| Project: | Wollongong Central and West Keira Development | Job No: | 60219101 |
| Subject: | Modification 4 - Response to Council Comments | | |

West Keira Redevelopment – Proposed Modification

Title	
SIGNAGE AND LINEMARKING PLAN SHEET 1	
Drawing No.	Project No.
CV1-00030	AA004213
Issue	
05

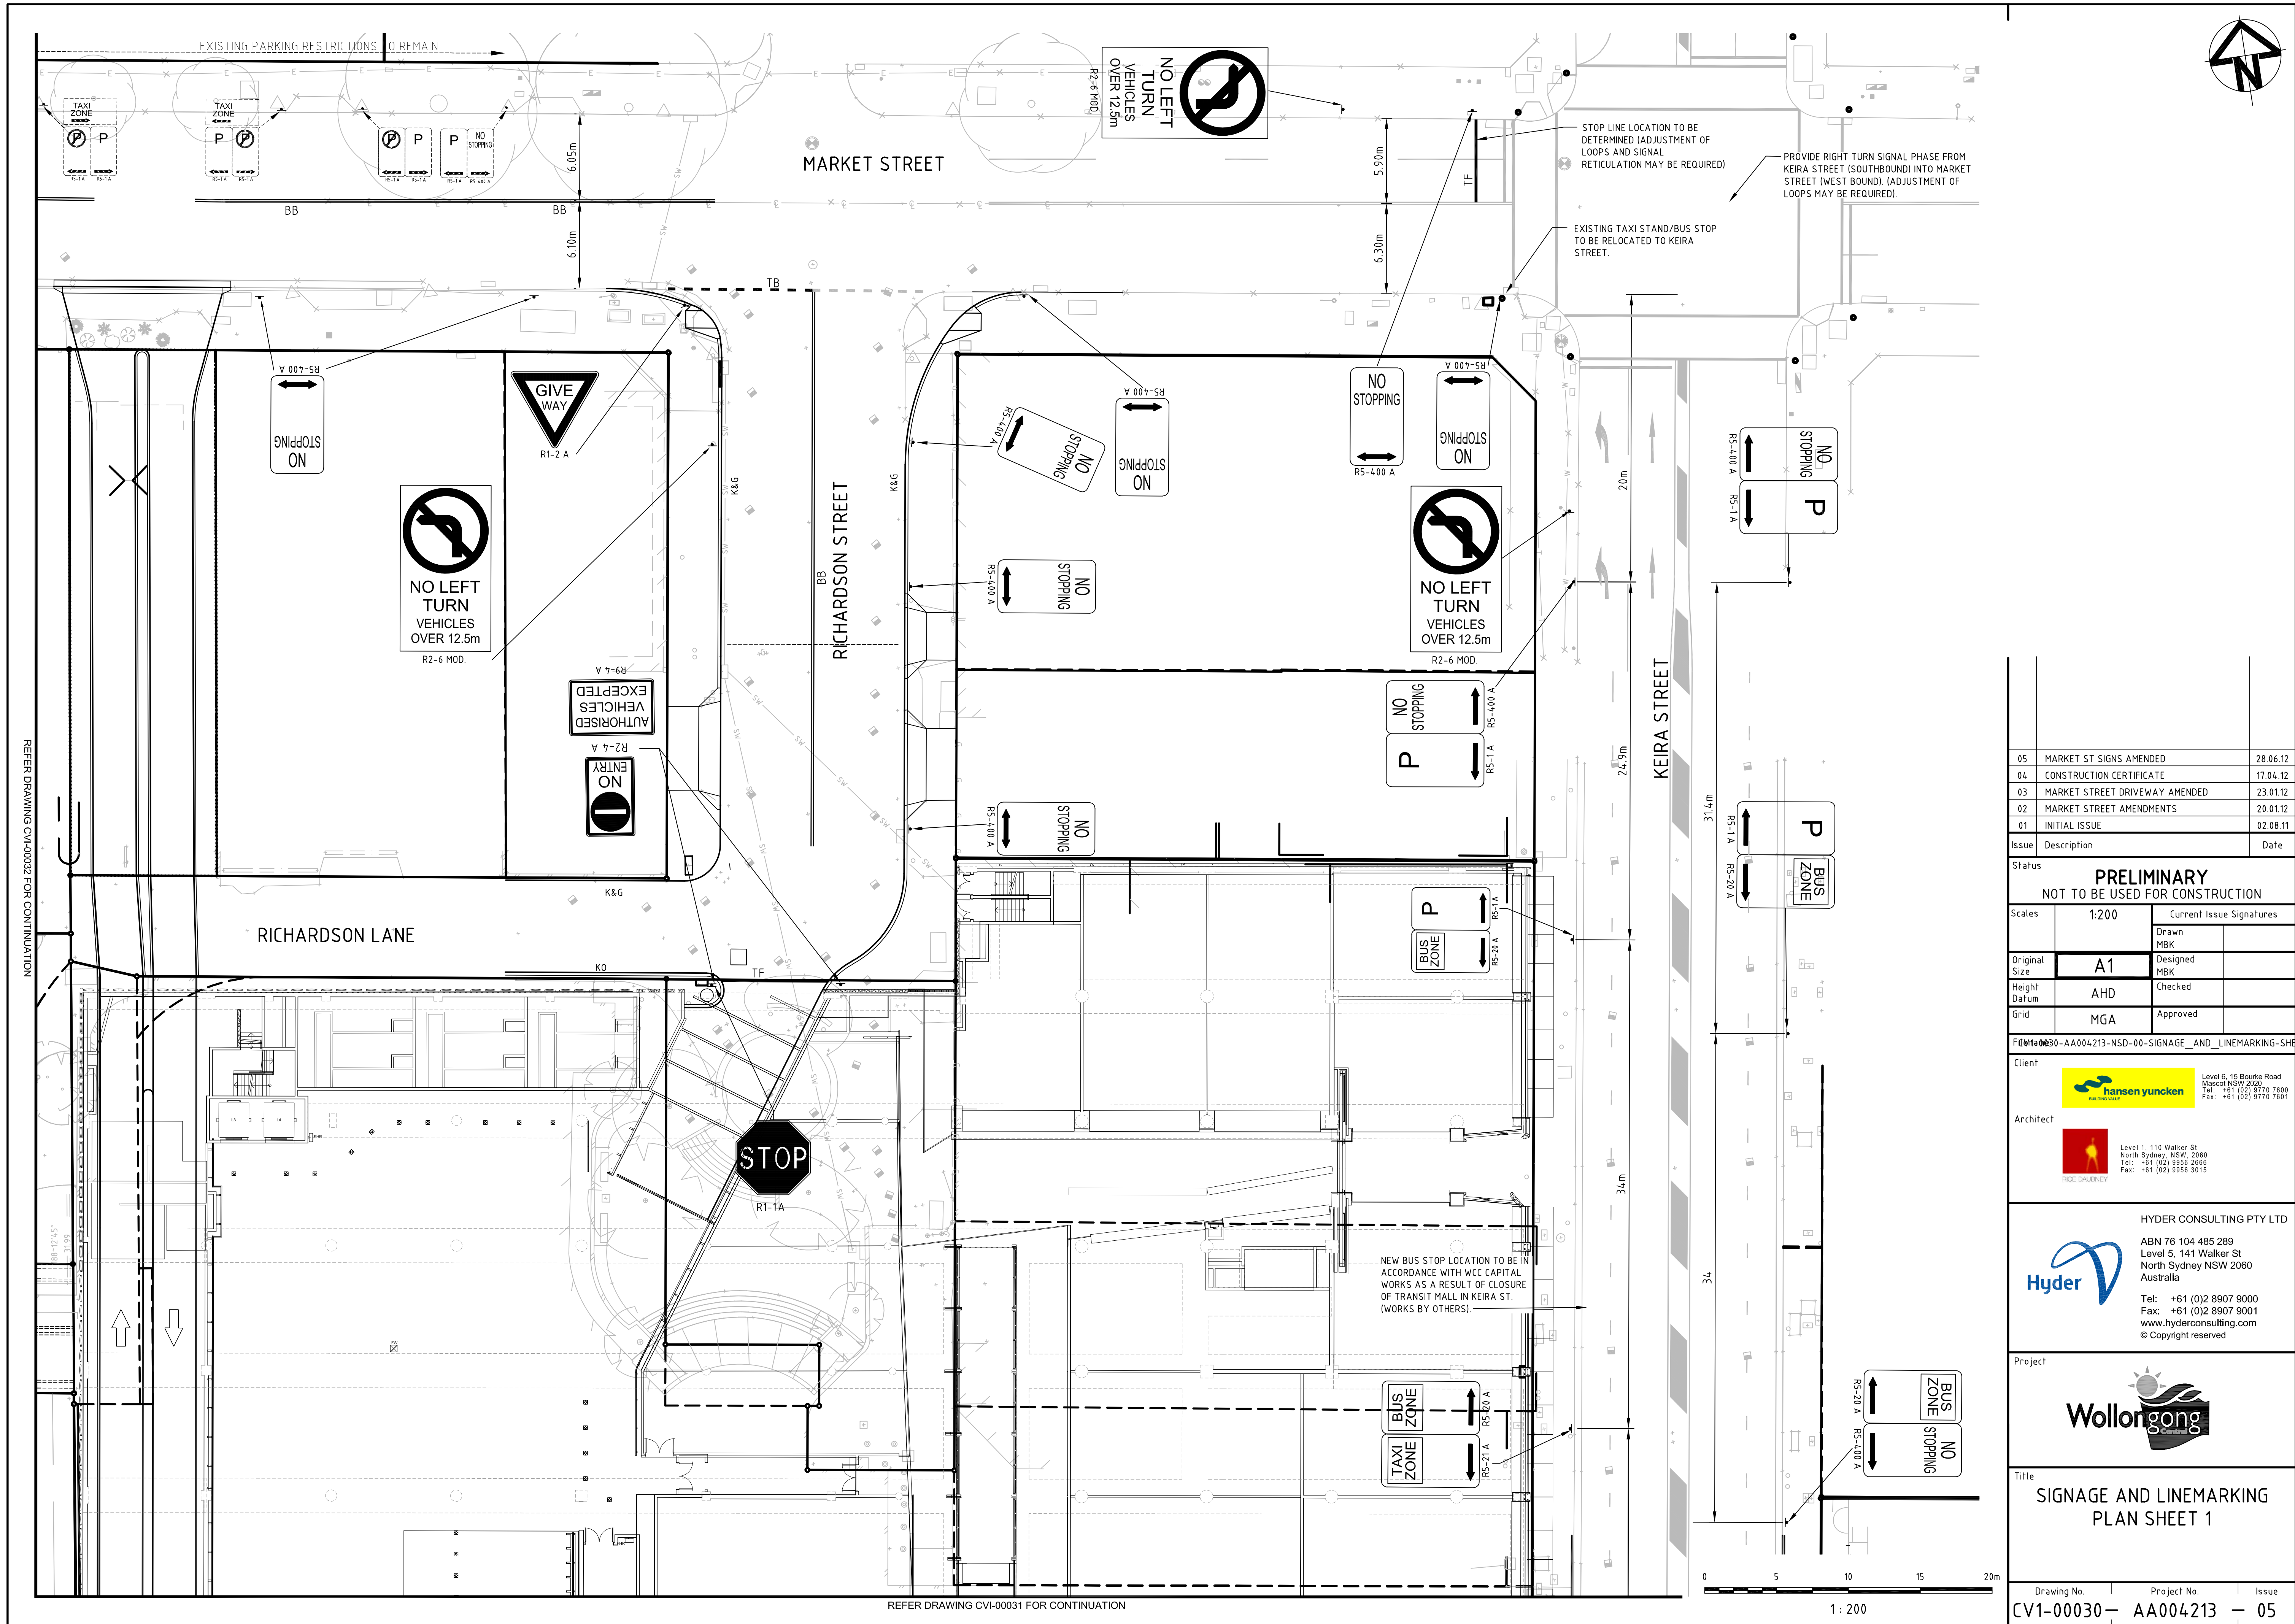
Cars exiting the site, particularly right-turns, may need to wait on the footpath obstructing pedestrian flow, This would result in potential pedestrian/vehicle conflicts as pedestrians are likely to walk in front of or behind cars while drivers look for gap in traffic. Drivers may suddenly exit once a gap in traffic emerges without seeing approaching pedestrians.

Appropriate signs and linemarking would be installed at the exit onto Market Street. Cars stopped at this location would have sufficient visibility of vehicles along Market Street. The traffic facilities would be positioned as such that motorists would not need to protrude onto the footpath and the vehicle will remain positioned within the property boundary, as shown in Figure 3.
